File: SF17/17332
Job ID: DOC17/120294

RE: Heritage Council comments on Narrabri Gas Project Environmental Impact Statement (SSD 6456)

Acting Manager, Conservation
Heritage Division
Office of Environment & Heritage
As Delegate of the Heritage Council of NSW
22 May 2017

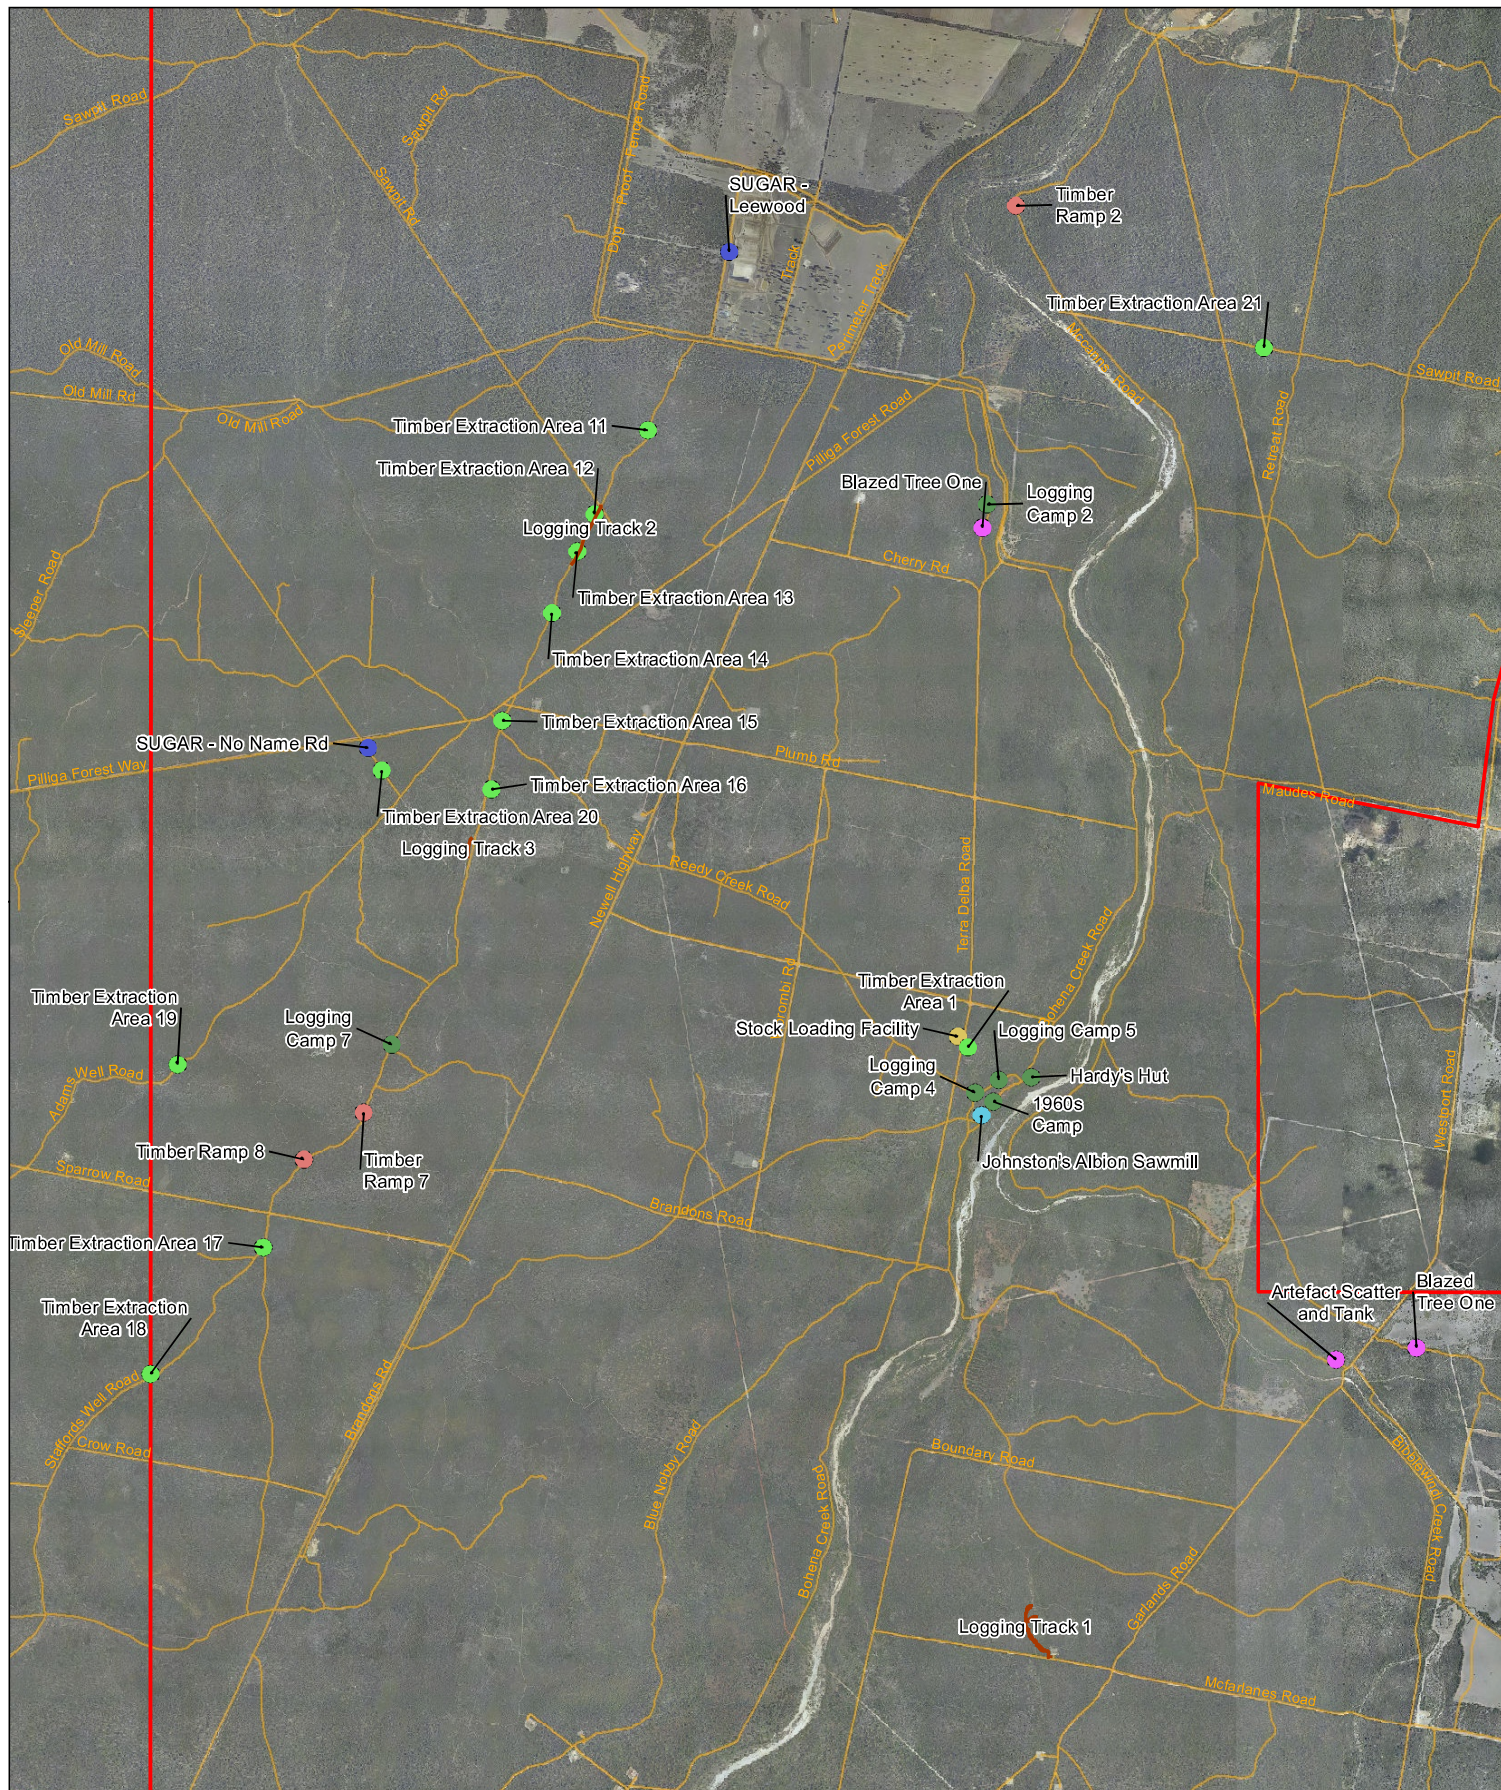
- Whilst it is acknowledged that the Johnston's Albion Sawmill has been substantially disturbed, the site should also be mapped and undergo photographic archival recording considering its historical use. A future consent condition should modify the recommended mitigation measures in Section 8 of the *Historic Heritage Impact Assessment* to incorporate mapping and recording of Johnston's Albion Sawmill; and
